REFUSAL OF PLANNING PERMISSION

APPLICATION NO: 3/2020/0933

DEVELOPMENT PROPOSED: Construction of rural farm shop with the inclusion of two retail units.
Resubmission of 3/2020/0444

AT: Clerk Laithe Slaidburn Road Newton BB7 3DY

PROPOSED PLANS &
ELEVATIONS

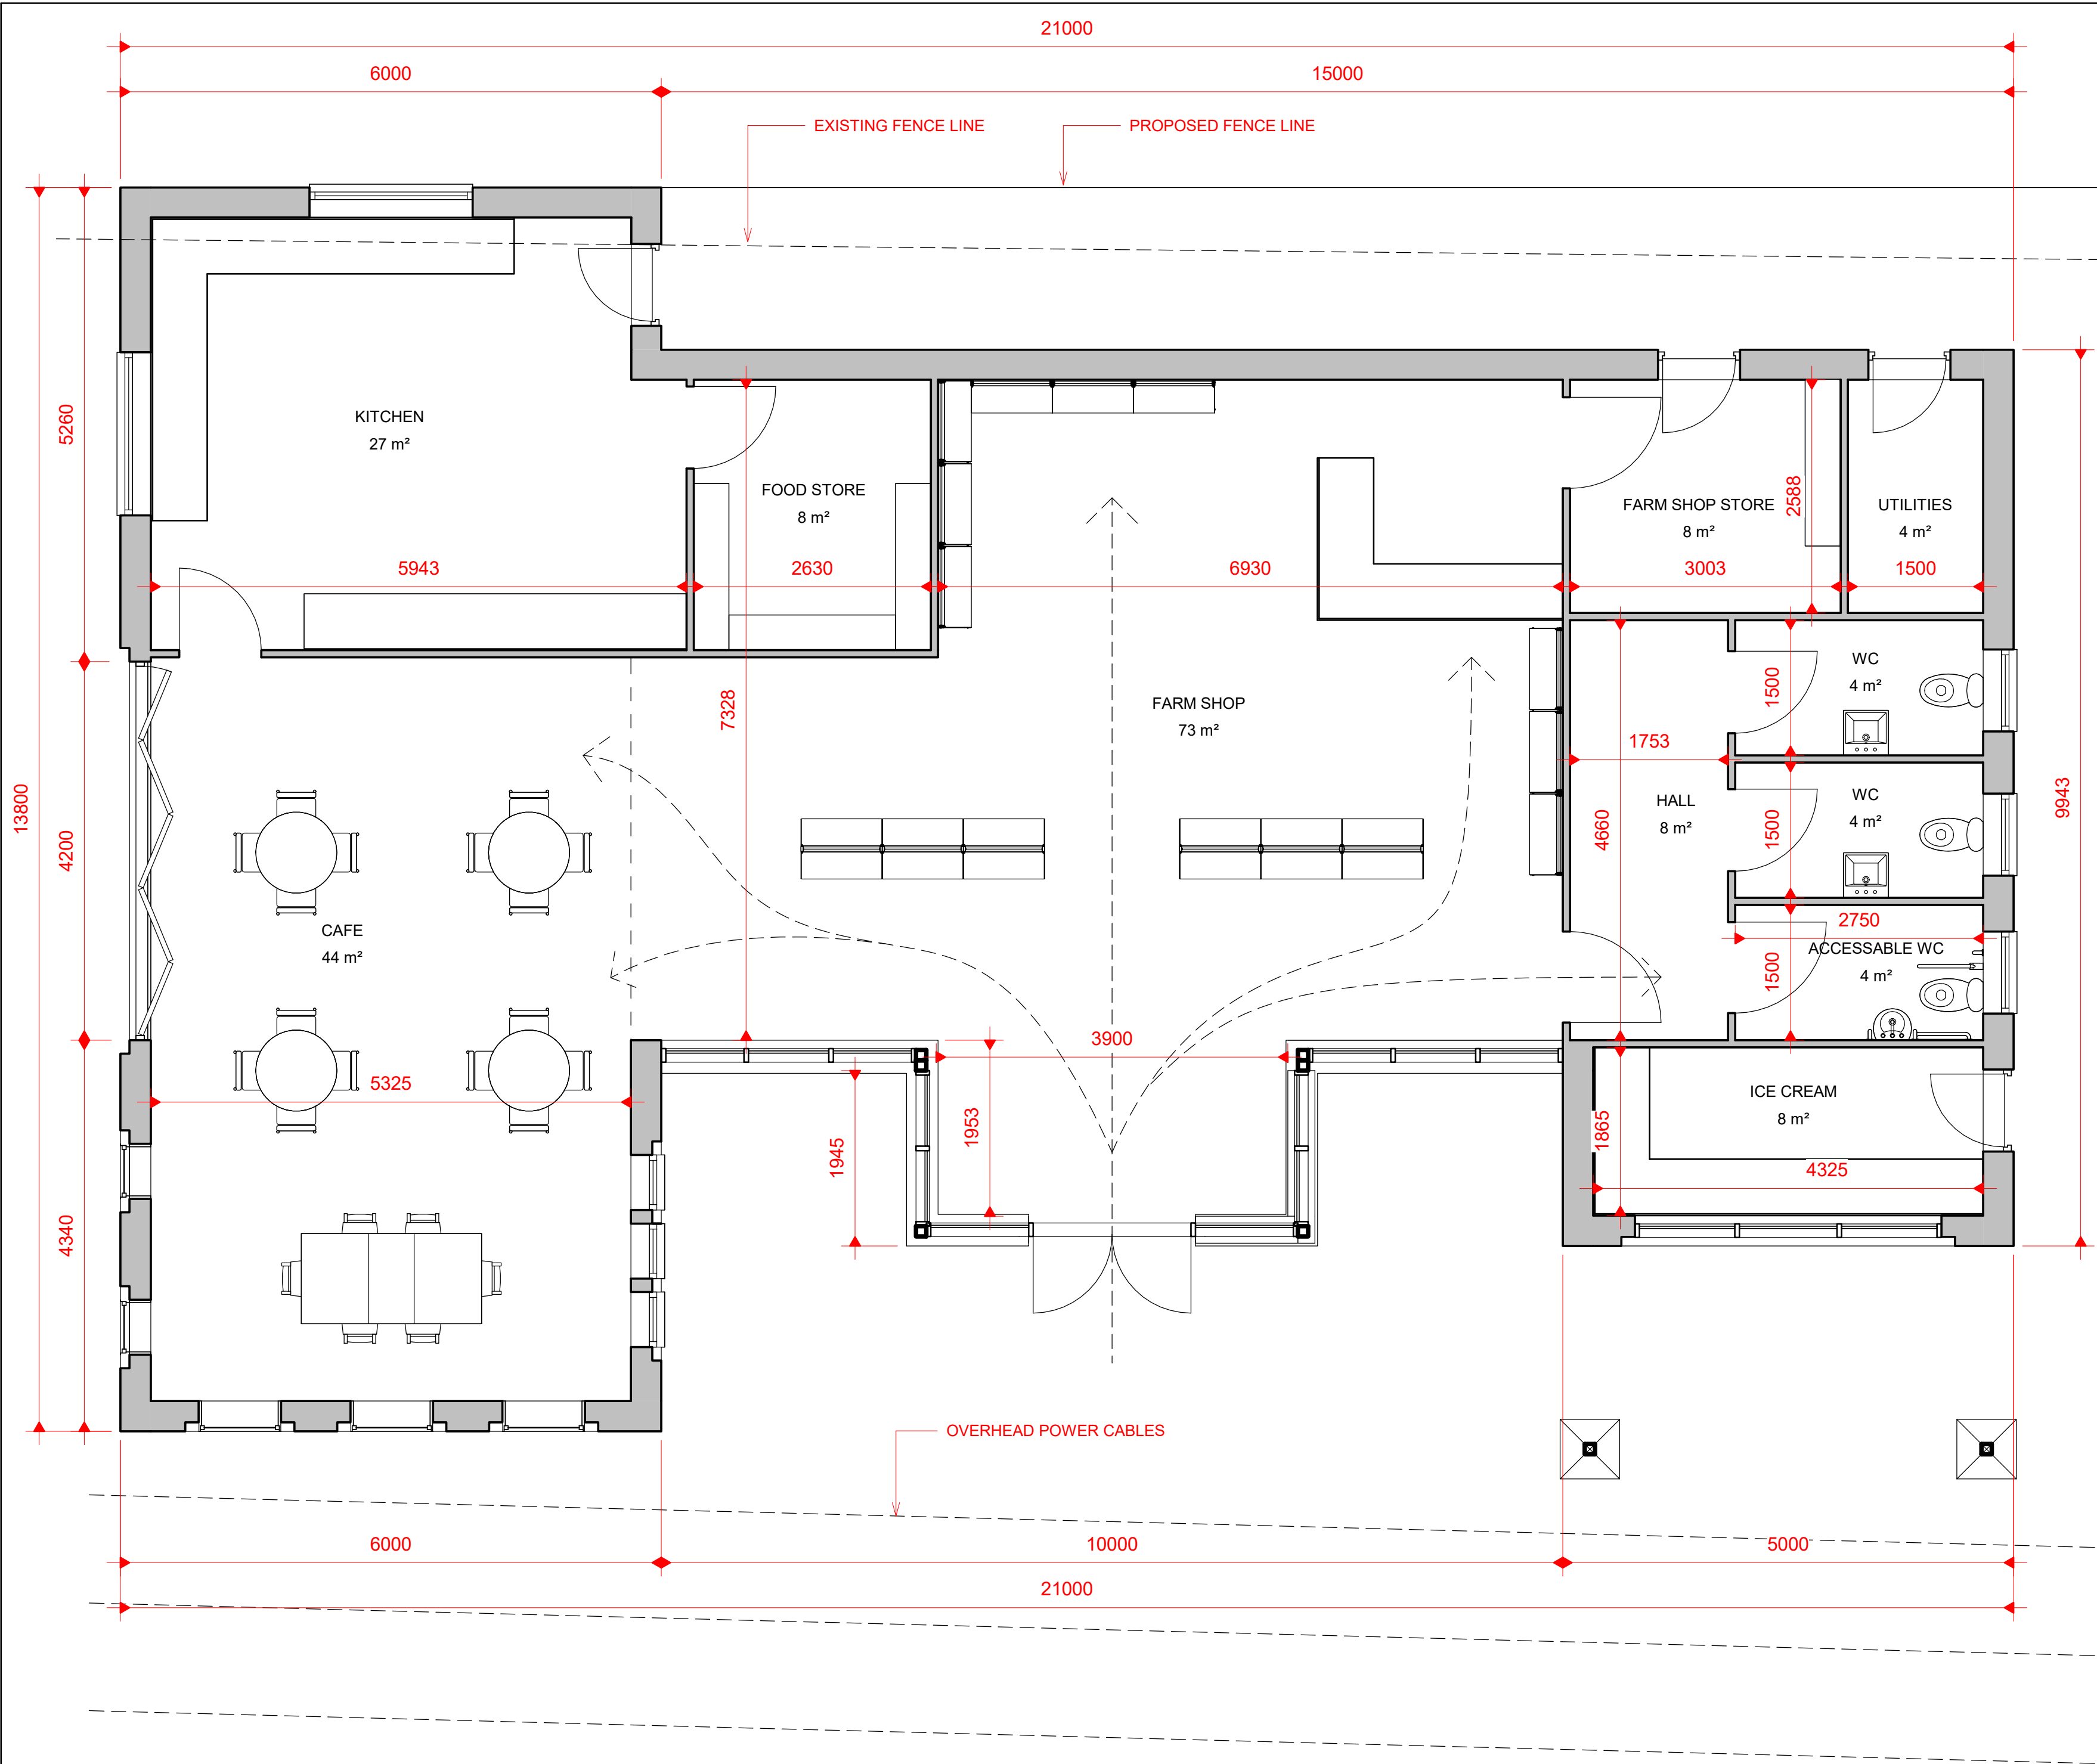
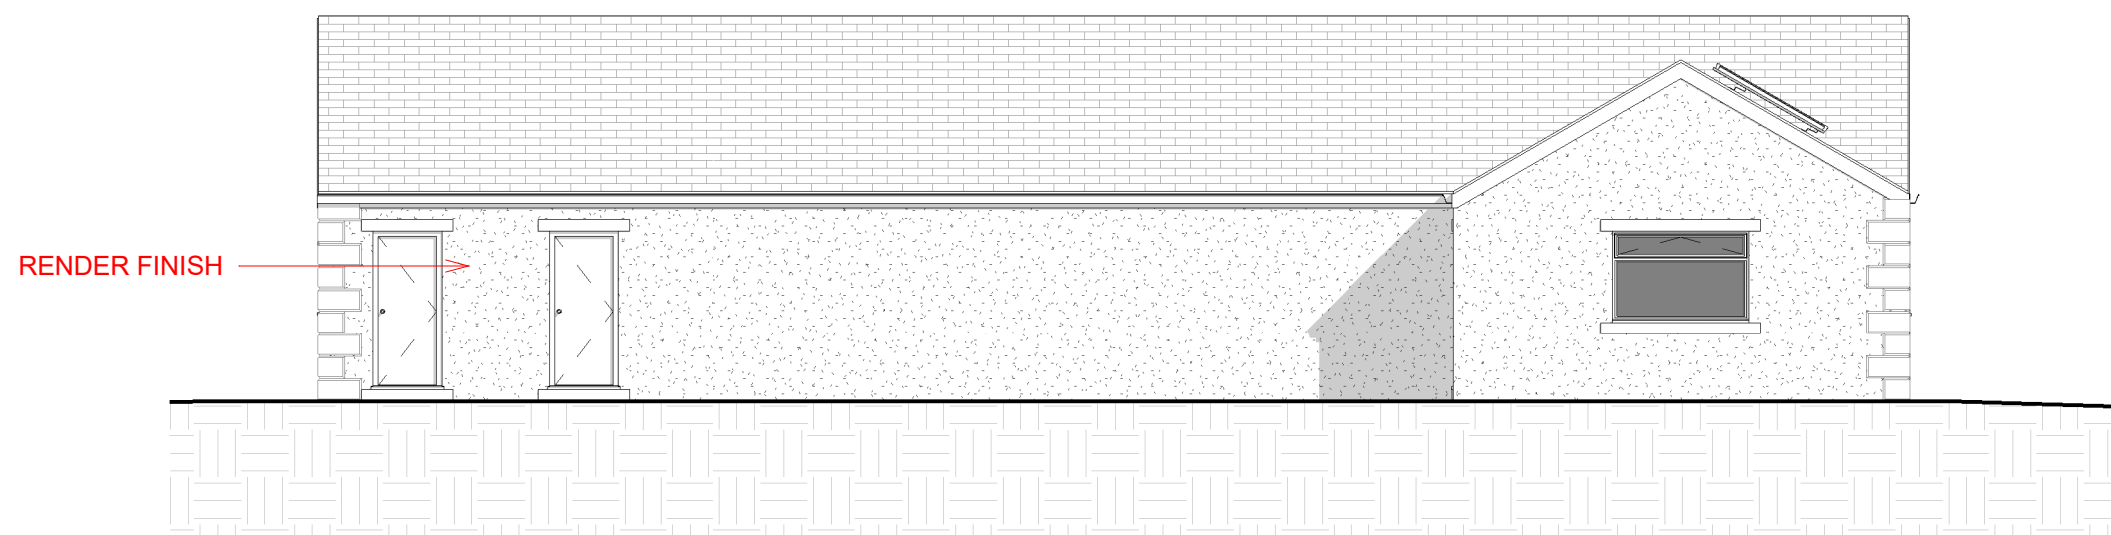
- 1 The proposal is considered contrary to Policy DMR3 insofar that it would represent the creation of retail functions outside of a defined settlement that is not linked to evidenced farm diversification. It is further considered that the proposal is in direct conflict with the requirements of Policy DMR3 insofar that the new building fails to be well related to existing farm buildings and when taking account of the scale of adjacent built-form the proposed building would not be considered to be of a minimal scale.

SHEET:
**PROPOSED SITE
PLAN**

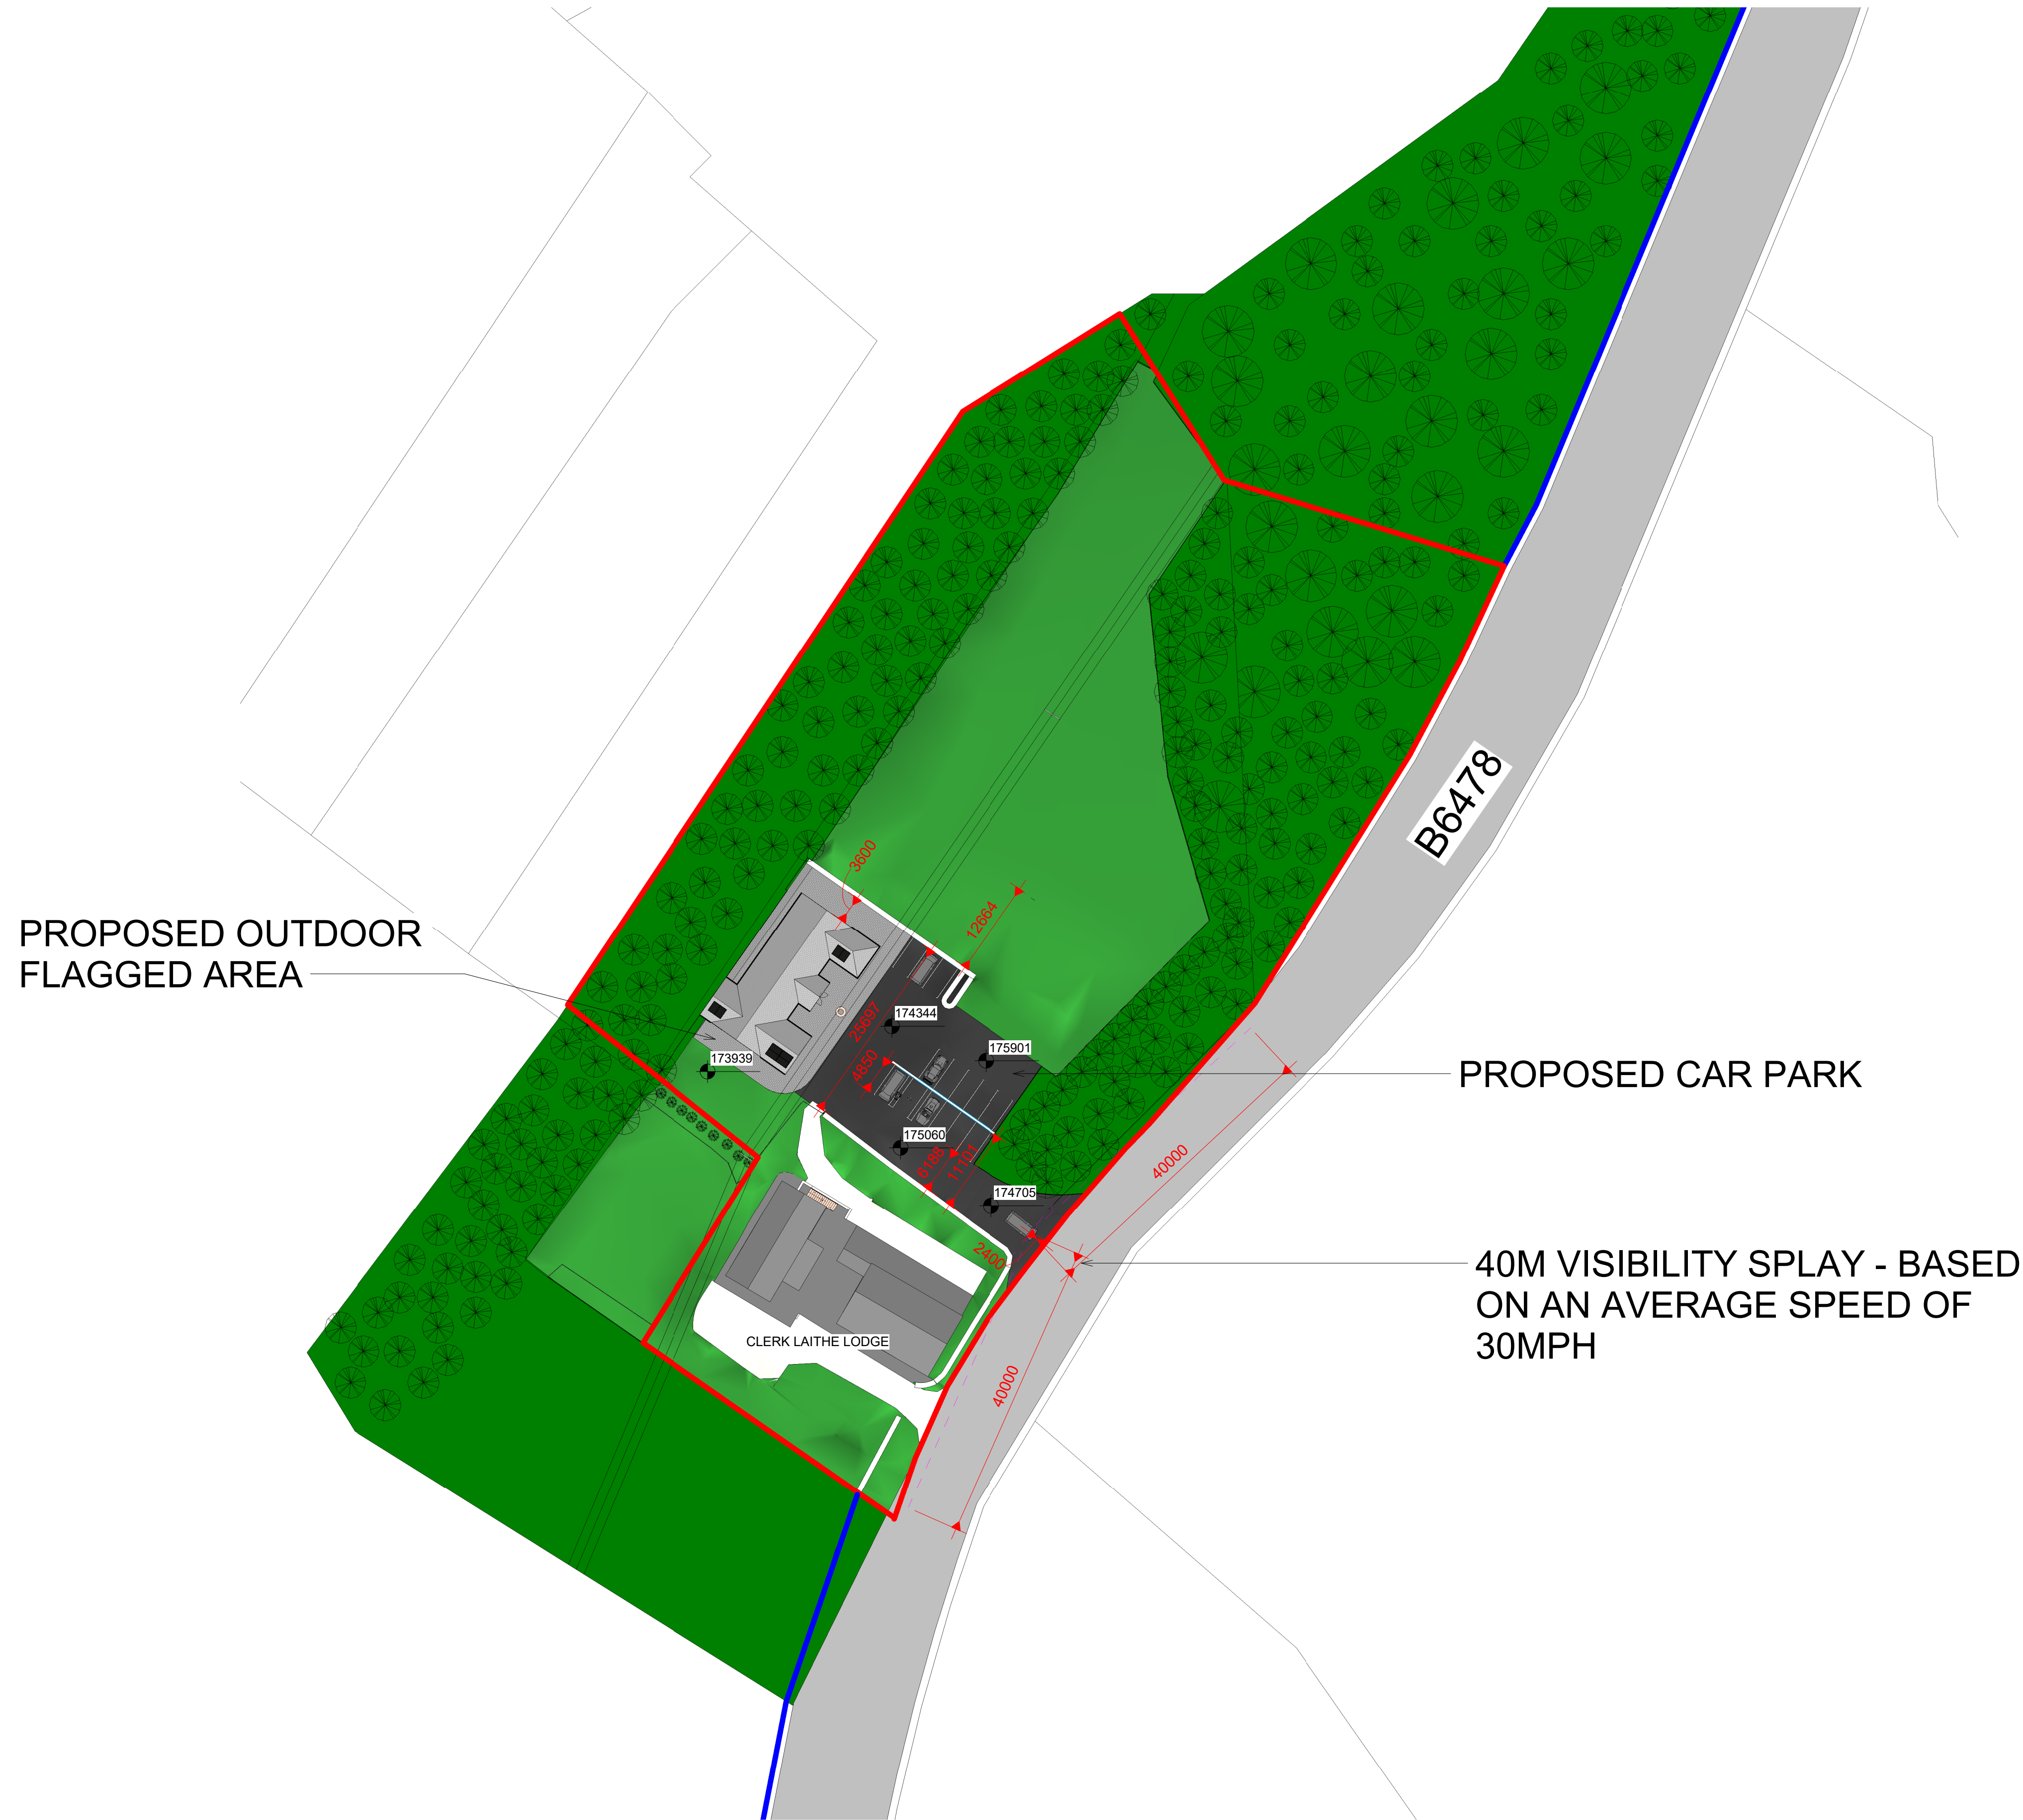
- 3 The proposed building and extent of parking provision, when read in concert with one another, and taking account of existing built-form, will result in an overtly incongruous, discordant and anomalous form and scale of commercial development that is uncharacteristic of the character of the protected landscape being of significant detriment to the character and visual amenities of the area. As such the proposal is considered to be in direct conflict with Key Statement EN2 and Policies DMG1 and DMG2 of the Ribble Valley Core Strategy.

-
- 4 The applicant has failed to demonstrate that adequate vehicular visibility splays can be both provided and maintained at the vehicular access point serving the proposal. As such it is considered that the proposal is contrary to the requirements of Policies DMG1 and DMG3 insofar that it cannot be demonstrated that the proposal will not be of detriment to the safe operation of the immediate highways network.
